Ribble Valley Borough Council
Council Offices
Church Walk,
Clitheroe
Lancashire
BB7 2RA

Phone: 0300 123 6780
Email: developeras@lancashire.gov.uk
Your ref: 3/2025/0864
Our ref: 33/2025/0864/HDC/KW
Date: 15 December 2025

Location: Braeside Old Back Lane Wiswell
Proposal: Proposed infill rear extension and alterations to the fenestration and external appearance of the dwelling, including associated landscaping works.
Grid Ref: 374405 437391

A1.01

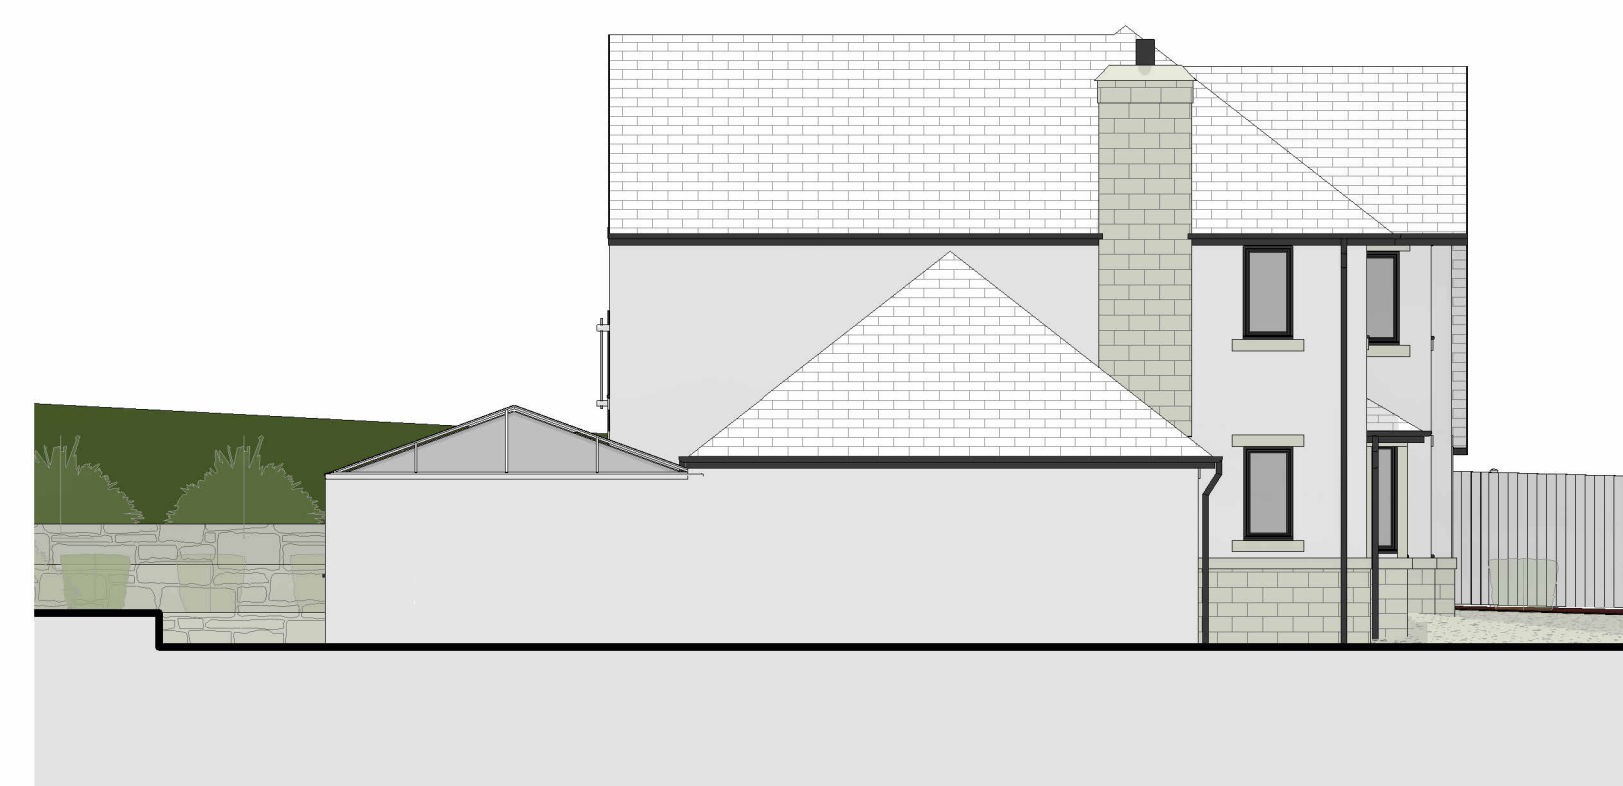
The LHA has reviewed the Proposed Site Plan & Elevations drawing, A1.01, and note that the site will be accessed via a new access onto a private access road. The proposed access will be positioned centrally within the site, with the existing access sited on the eastern boundary of the site. The proposed access point is an improvement to the existing conditions, with the proposed access positioned in a way to provide more control over visibility in both directions. The application includes the addition of boundary walls and a gated access, which are set back to support a clearer line of sight. The access is an appropriate width to serve a dwelling, and the gates are set back 5m, which will allow vehicles to turn into the access before operating the gates, reducing conflict on the private access road.

The LHA have reviewed the Proposed Site Plan & Elevations drawing A1.01 and are aware that the dwelling complies with the LHAs parking standards as defined in the Joint Lancashire Structure Plan. There is also room to manoeuvre within the site, allowing for ingress and egress in a forward gear.
